**Cllr John Walsh**  
**Labour Party – Dublin West**

**Submission to An Bord Pleanála**  
**Railway Order for DART+WEST**

# Ashtown

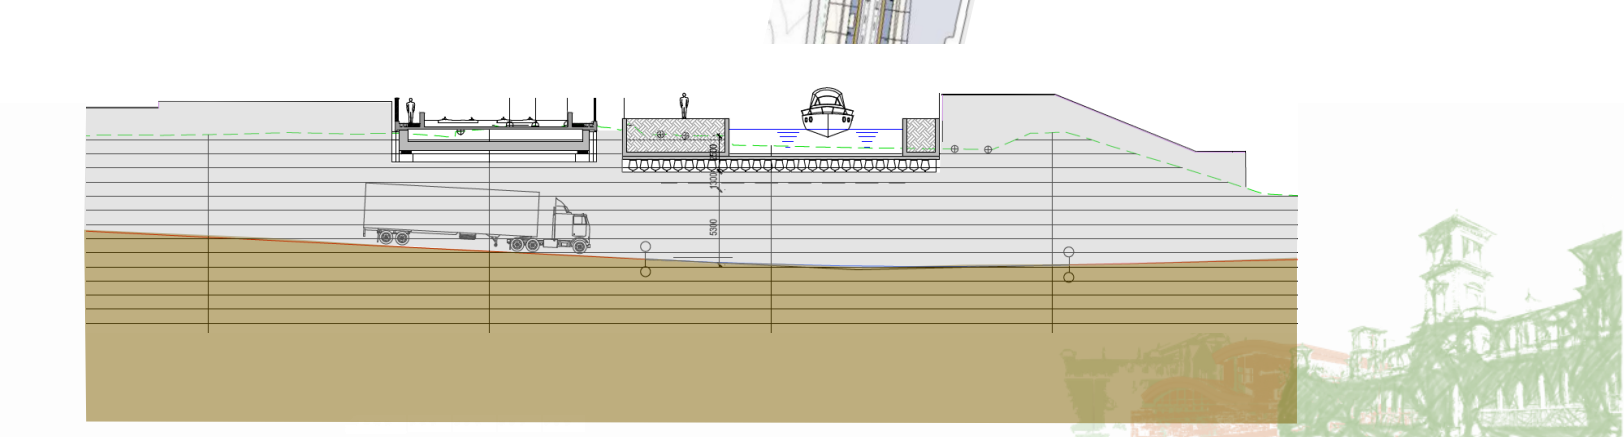
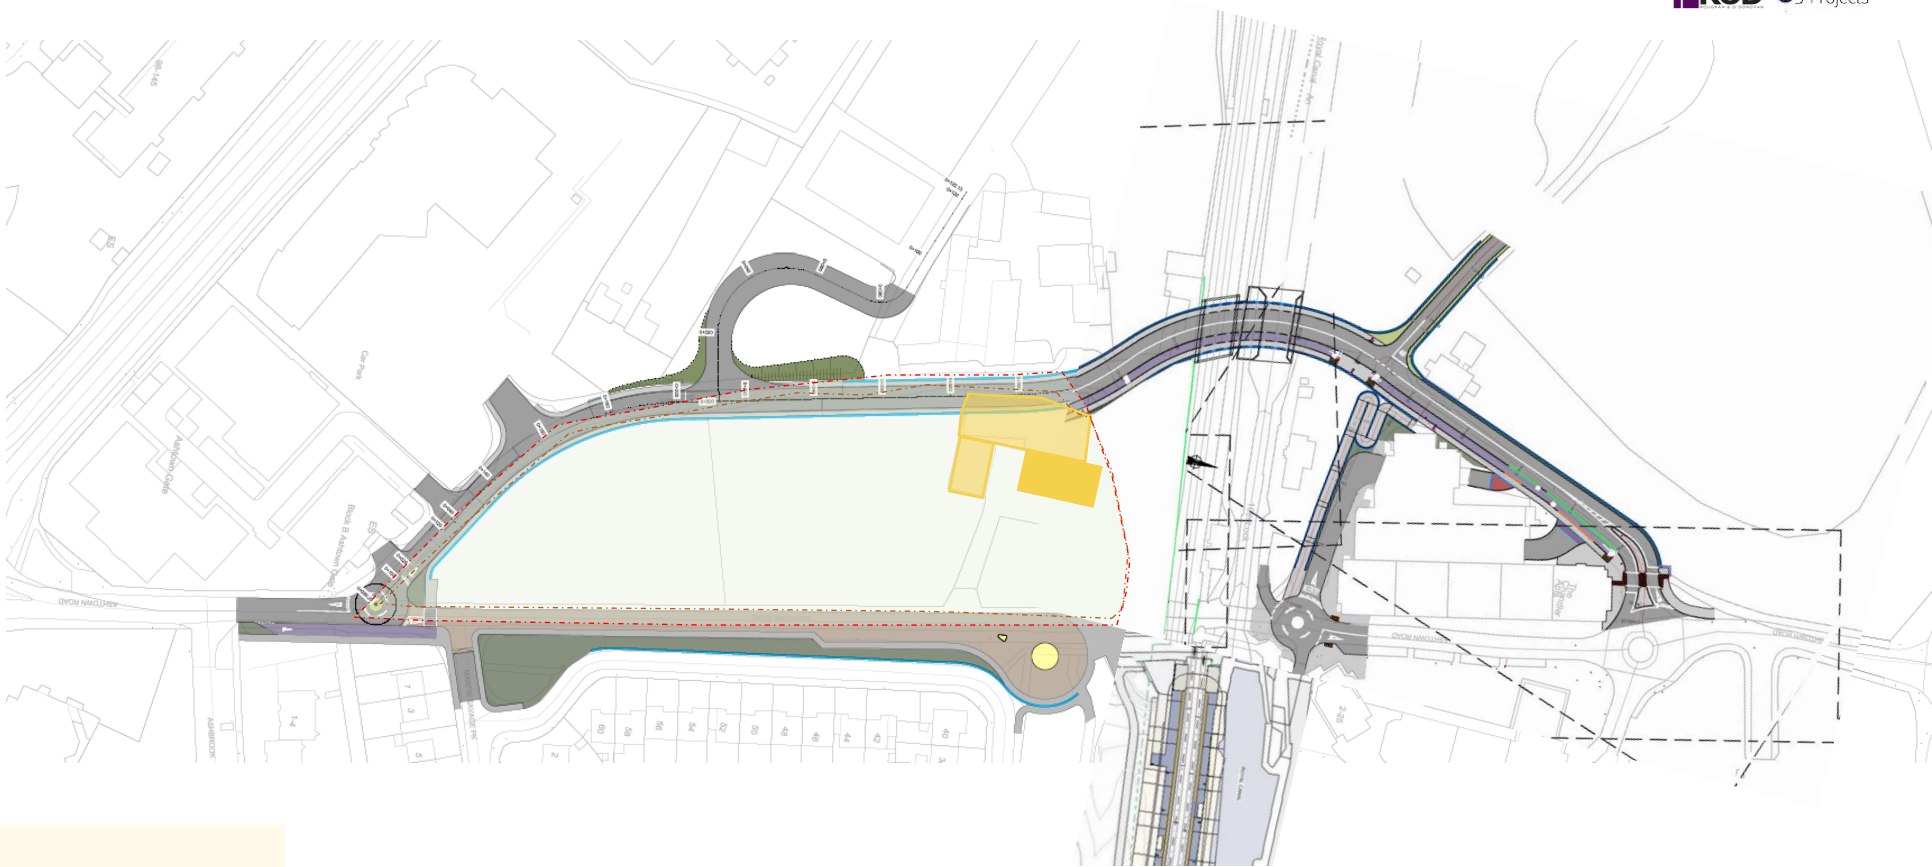
The original proposal for an underbridge to replace Ashtown level crossing involved the destruction of Ashtown stables. While it is welcome that Irish Rail has sought to reduce the impact on the stables by re-routing the underbridge, this proposal still threatens the ongoing viability of Ashtown stables.

I believe this is the wrong option for Ashtown due to its significant, negative impact on heritage, local business and residential amenity. In particular I disagree with the proposal to continue with a tunnel/underbridge at a different location rather than

adopting a more radical redesign of the plan, involving either a lowering of the rail line or an overbridge at a slightly greater distance from Ashtown level crossing and the nearby heritage and protected structures. I would like to raise the following concerns about the proposals:

- The continuing development of an underbridge/tunnel increases the risk of anti-social behaviour and criminality, as such underbridges or underpasses in suburban Dublin have had a long history of anti-social behaviour and frequently more serious criminal activity.

- Ashtown stables are operating on the bare minimum footprint for their activity and Irish Rail's current plans would turn an unnecessarily large area around the Stables into a construction site. This would render Ashtown Stables inoperable and force the stables to close. It should not be acceptable to allow the loss of such a valuable community and recreational amenity which serves young people across the Dublin 15 area.

- An Táisce has argued that the 'proposed Ashtown tunnel is disproportionate in terms of the advantages of carrying out such a massive civil engineering project in a lightly trafficked suburb of Dublin.'

- The proposed route is likely to have a damaging impact on neighbouring estates such as Martin Savage Park where the removal of trees is disappointing and should be avoided.

- The works will also have a very damaging impact on commercial properties, particularly Burke Brothers whose business will effectively be unable to operate for the duration of the project.

- The proposed underpass and associated works would have a significant visual impact on heritage and protected structures in the Ashtown area (such as Ashtown Mill) and the works also impinge on the curtilage of Ashton House – this kind of impact on demesne lands should be avoided.
